# CITY OF ALBUQUERQUE

**RE: Iron Duplex - Resubmittal  
Grading and Drainage Plan  
Original Stamp Date: 11/22/16  
Revision Stamp Date: 4/4/17  
Hydrology File: K13D074**

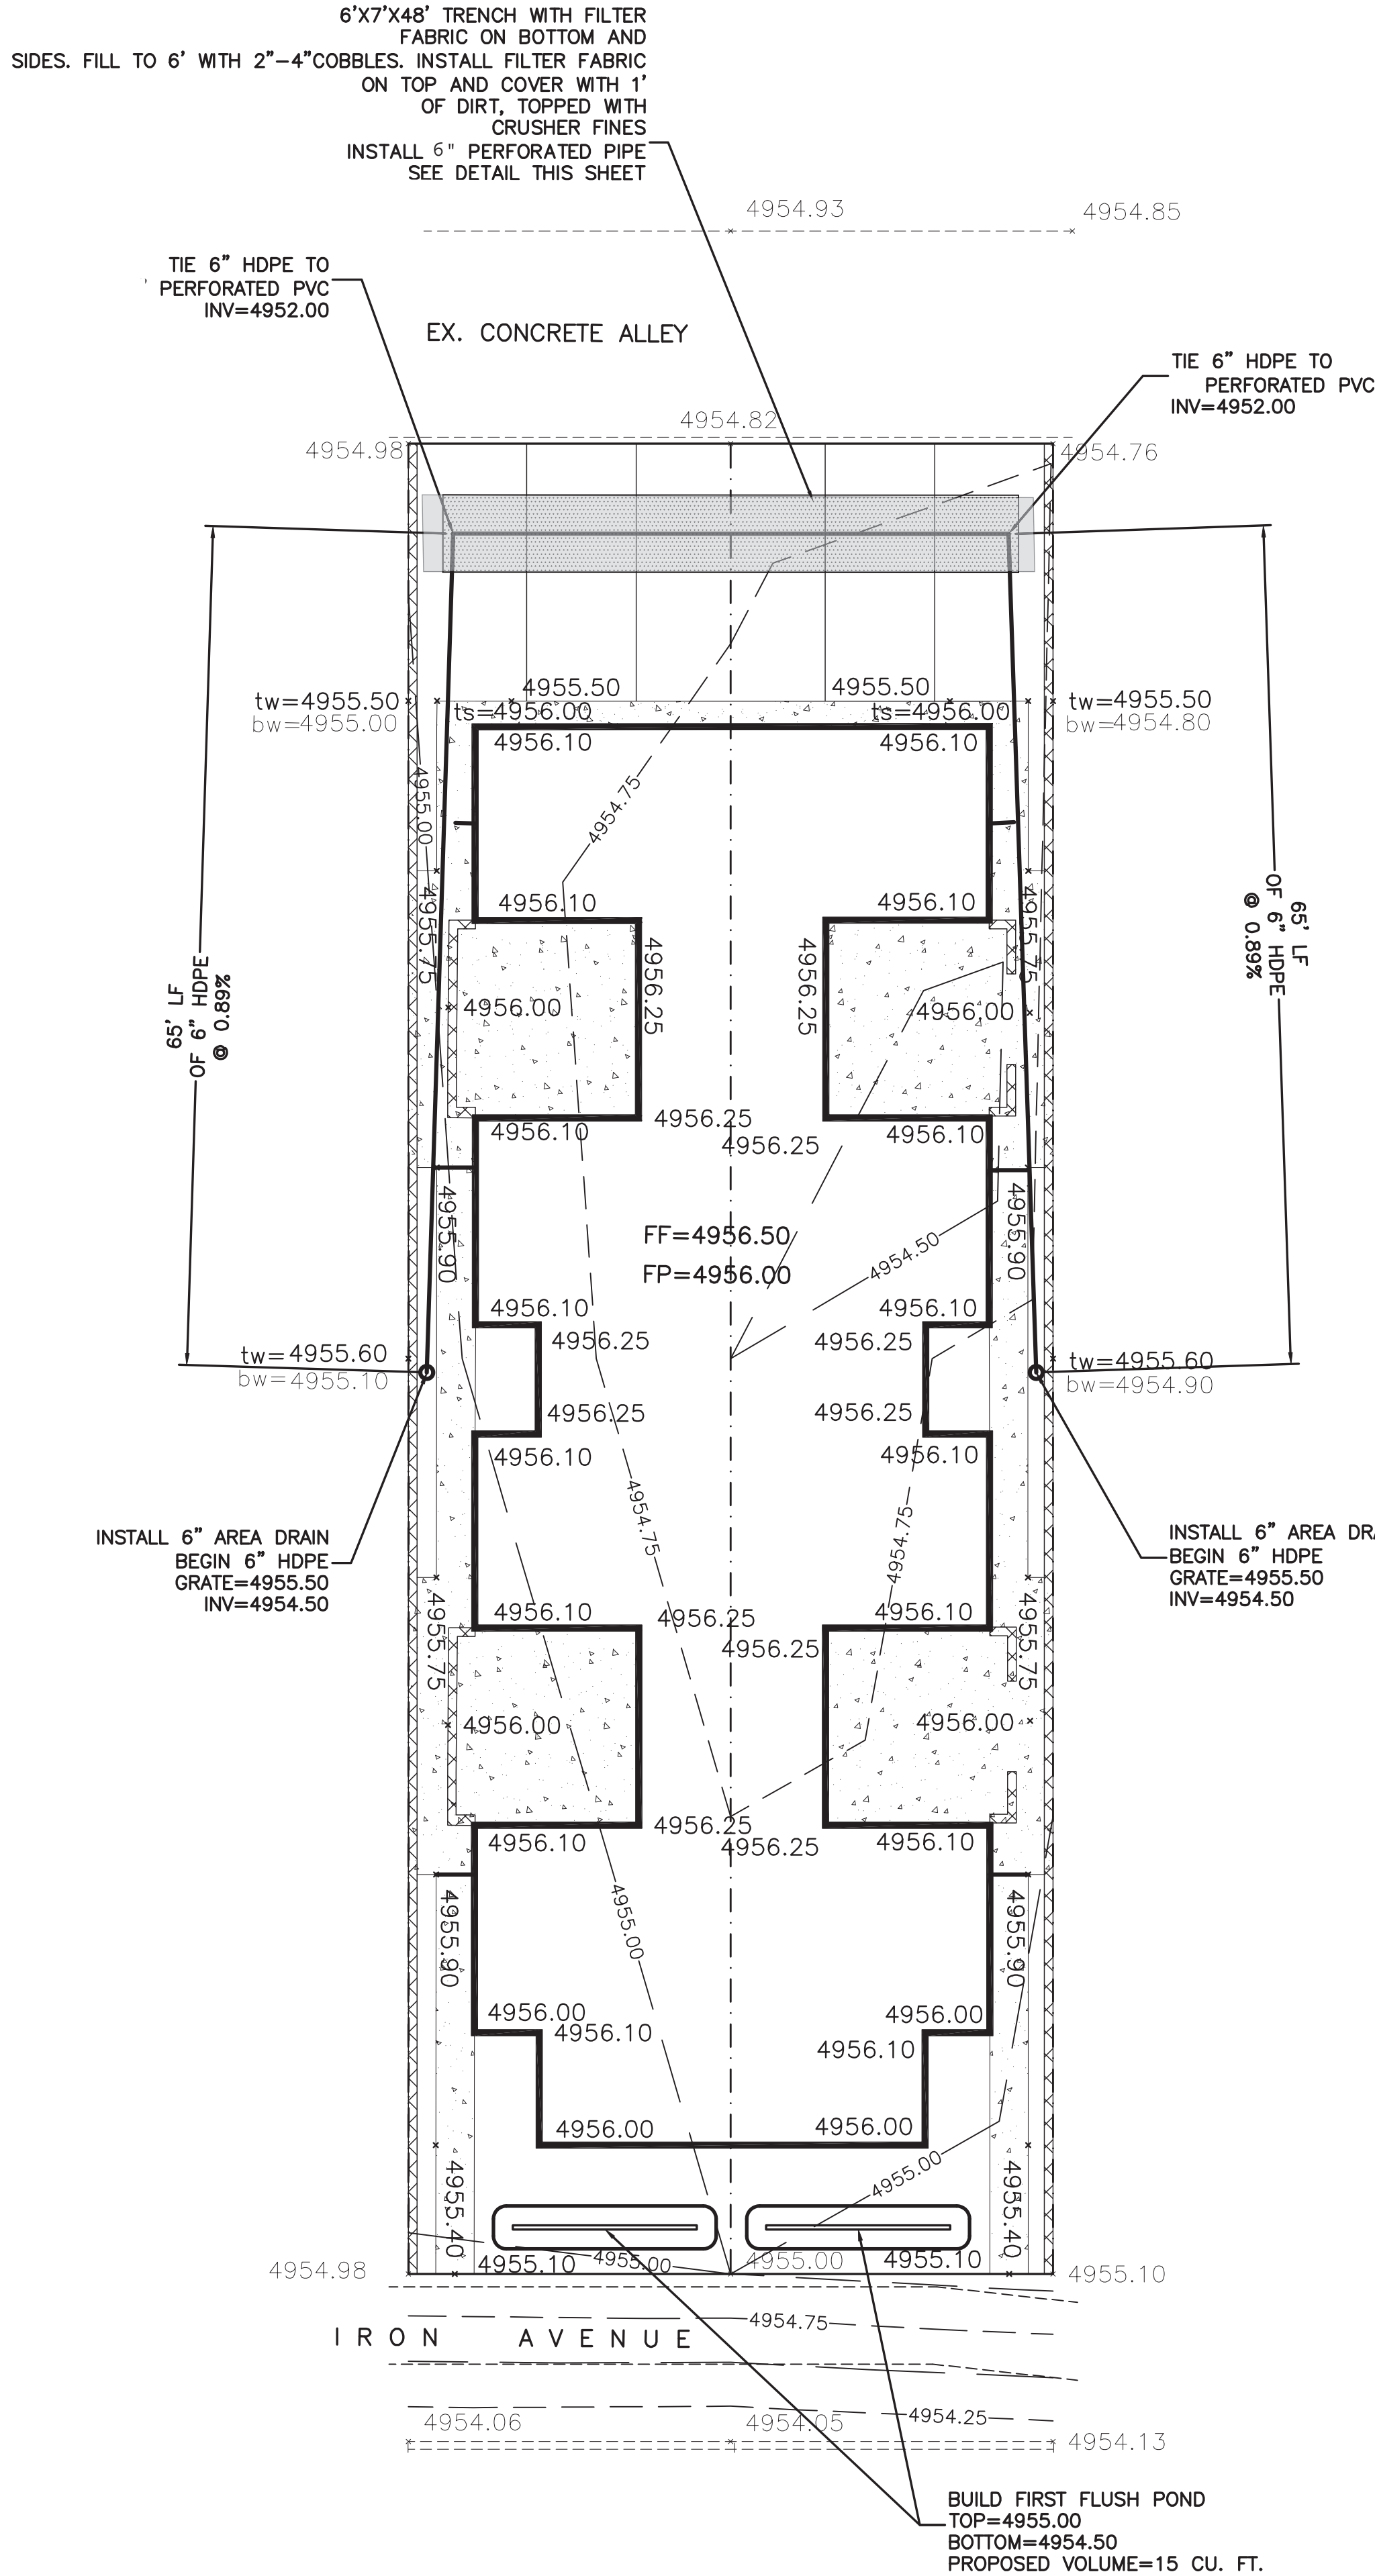
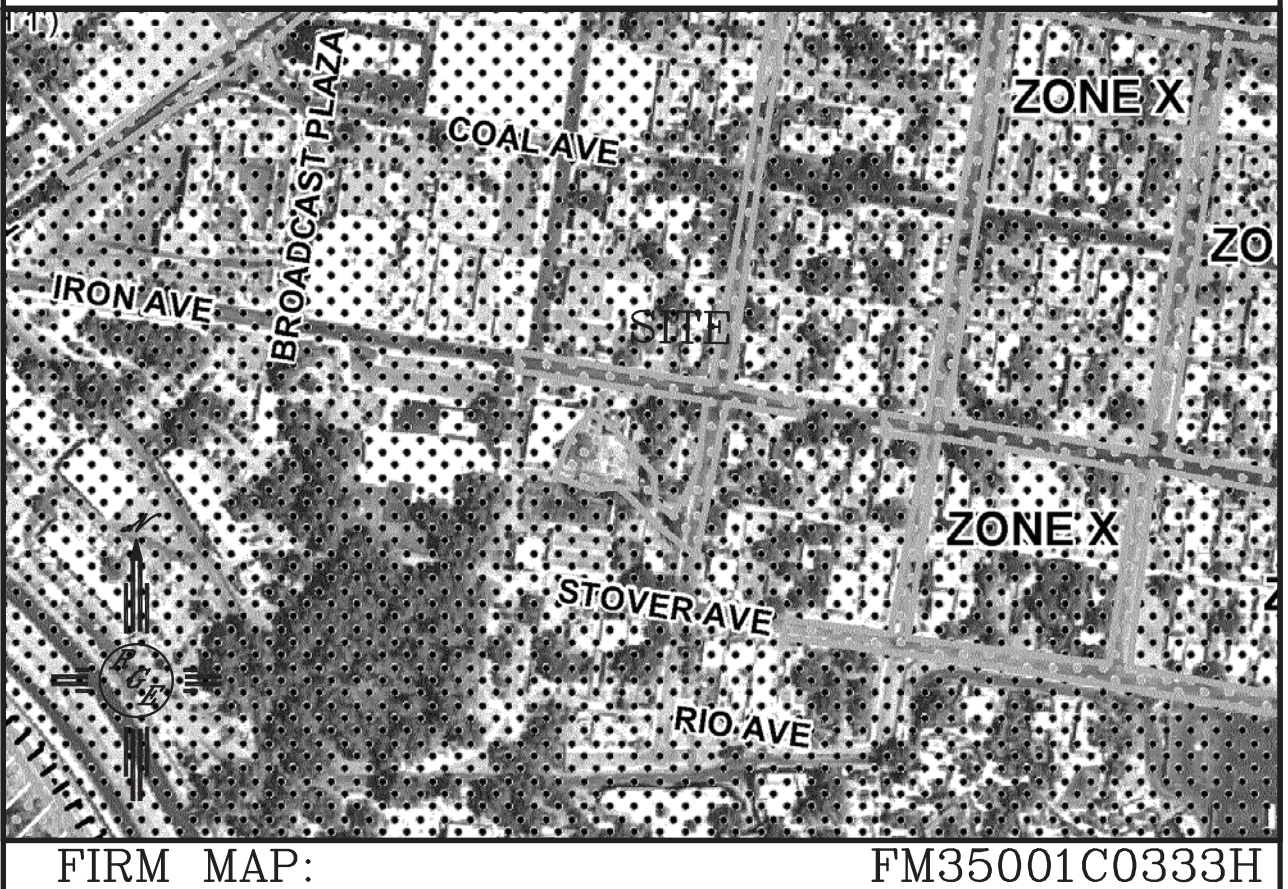
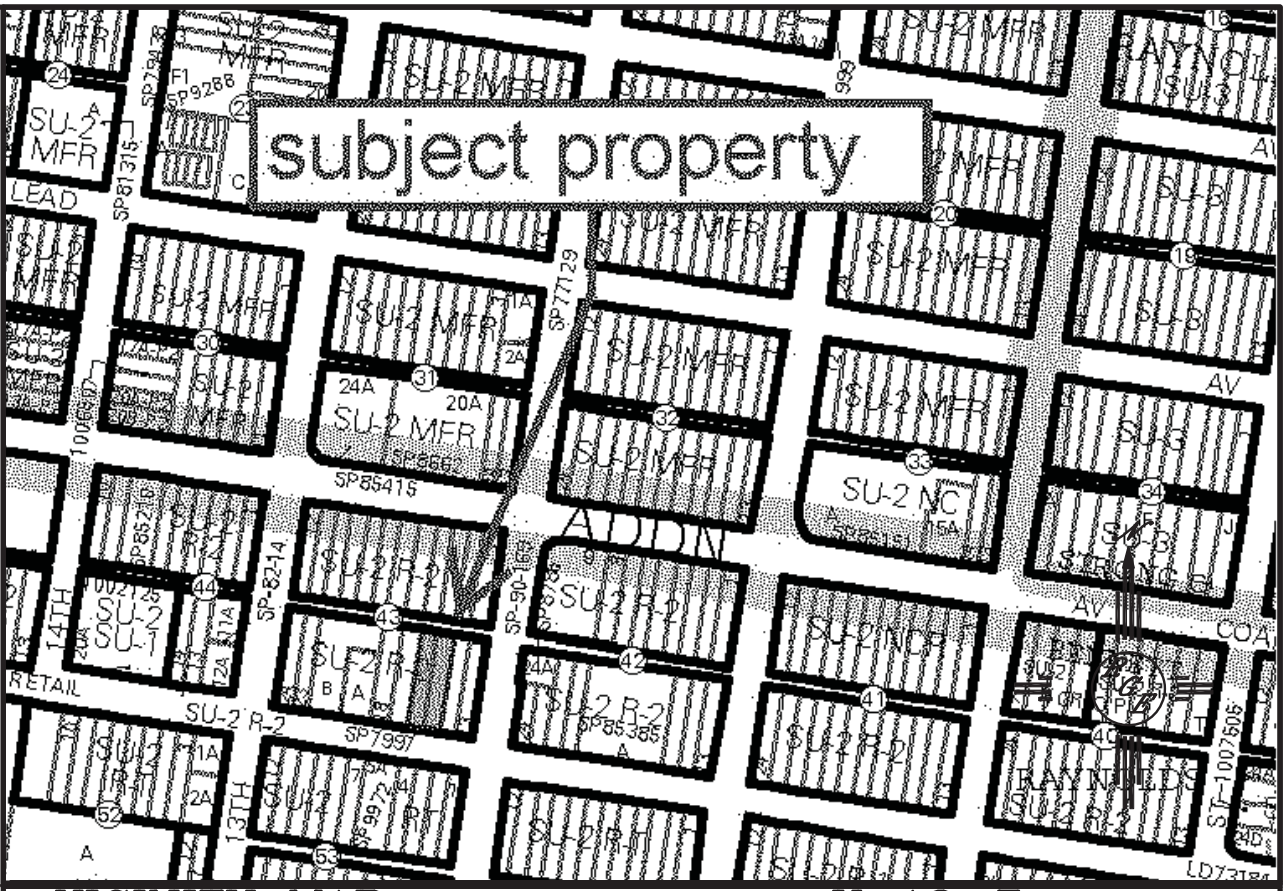
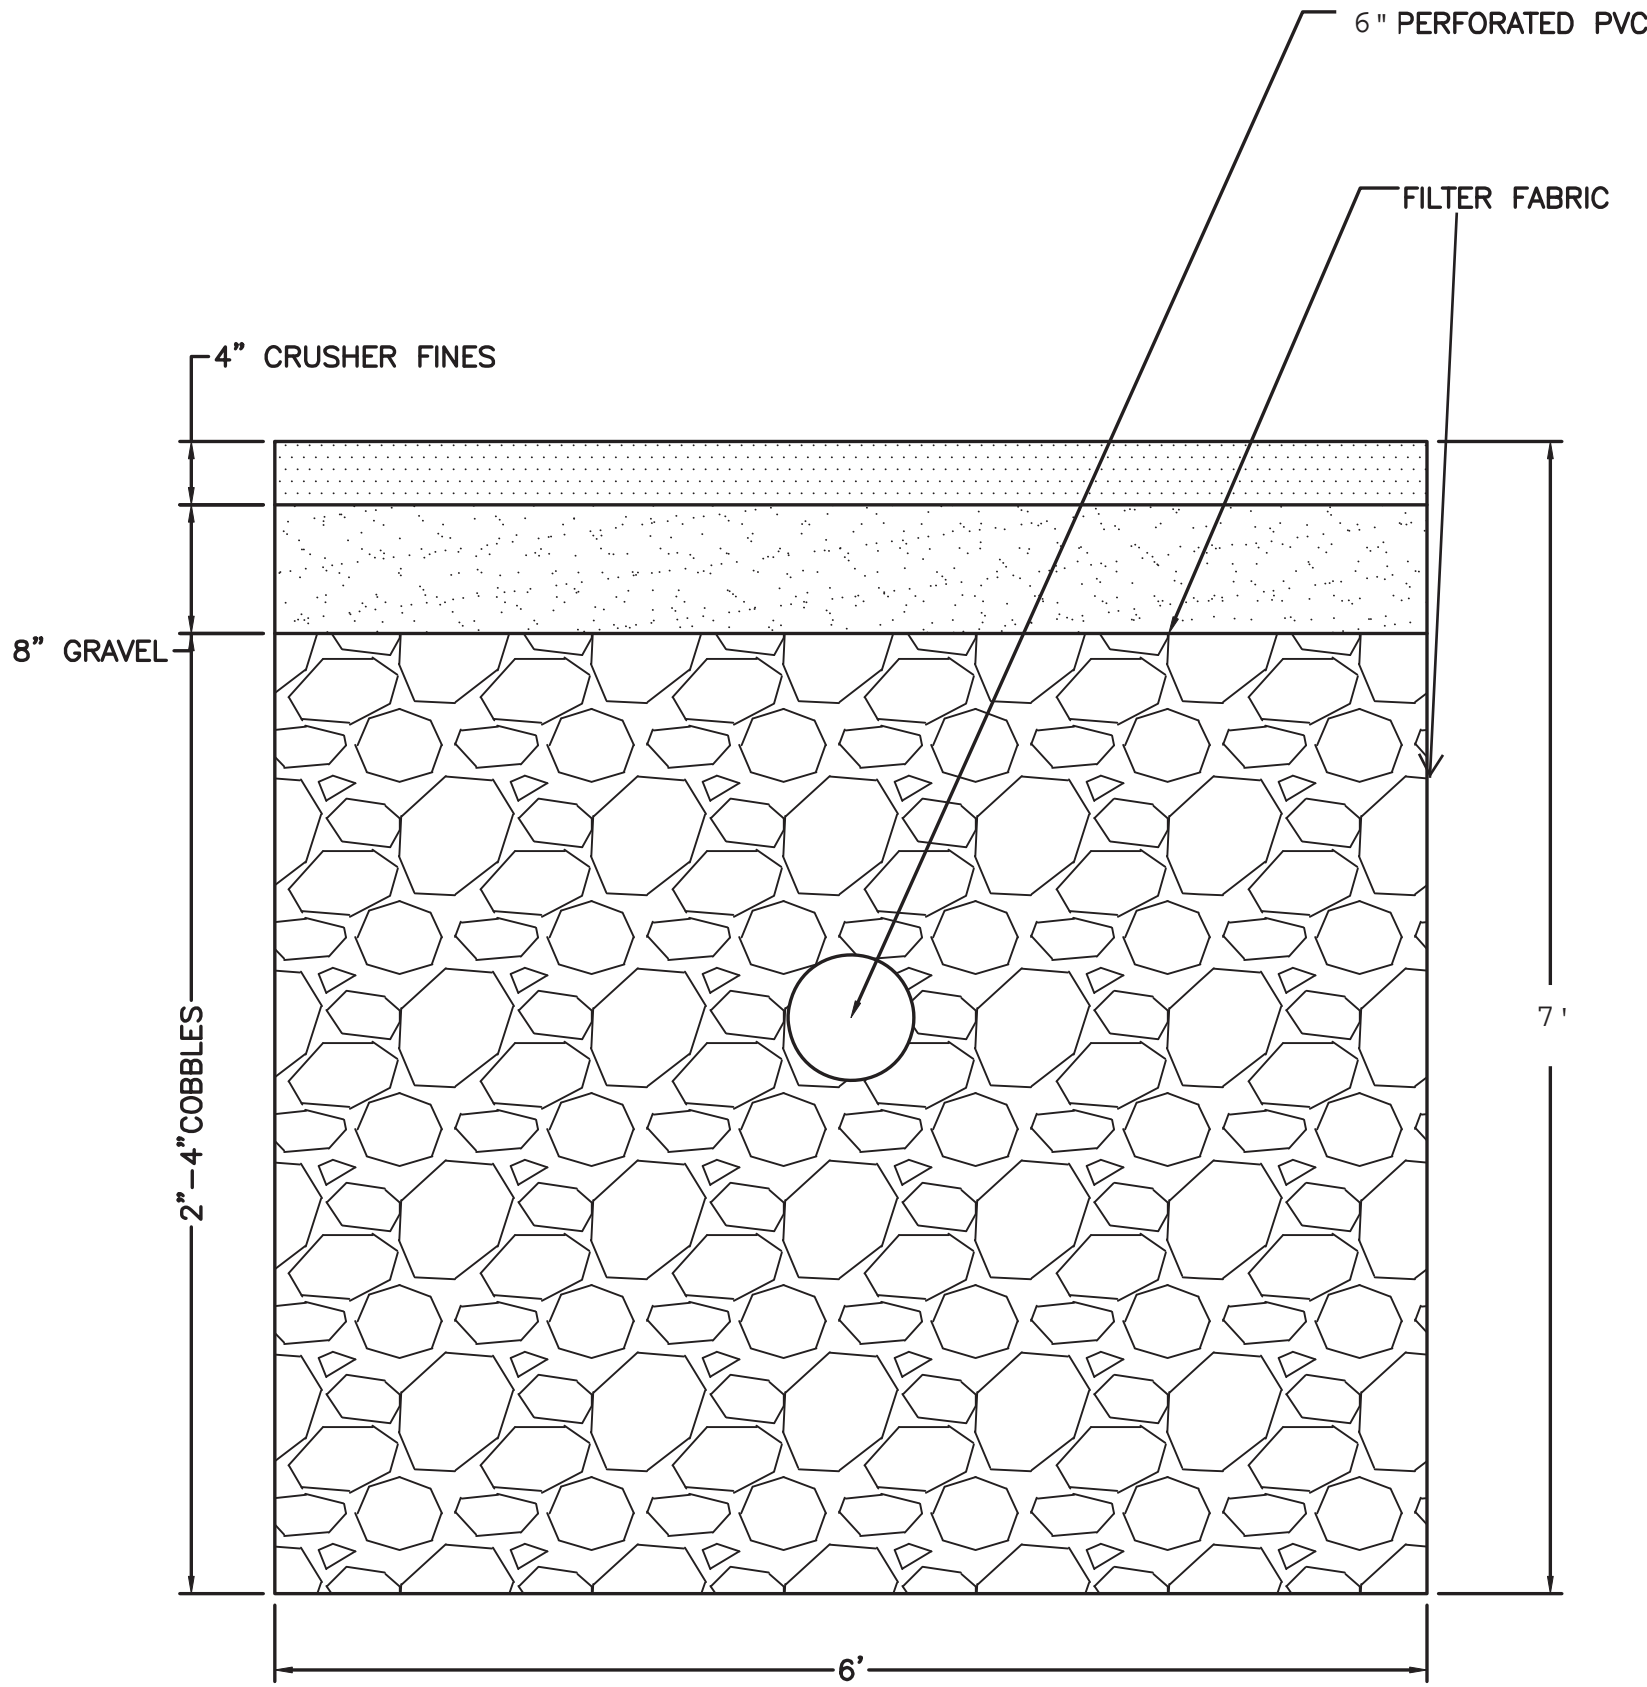
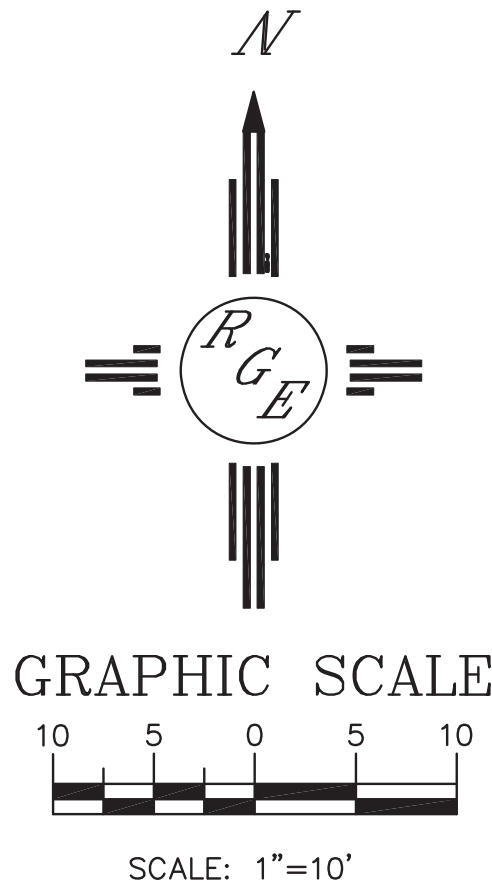
1. As a constructability issue, it is hard to tell what you are installing and what you are not. Please place a big "X" over the old ponds and driveway. Then place a new viewport showing what you are proposing to install. It will make it a lot easier for both the contractor and the building inspector to immediately see what is to be built.
2. It appears that the 6'x7'x48' trench is drawn 47'. Please check the length of the trench.
3. Please provide a detail for the trench. Again this will help both the contractor and the building inspector know what is to be built.
4. The proposed trench is to provide 520 CF of retention. The required retention is 530 CF. It appears that your new system is about 10 CF short.
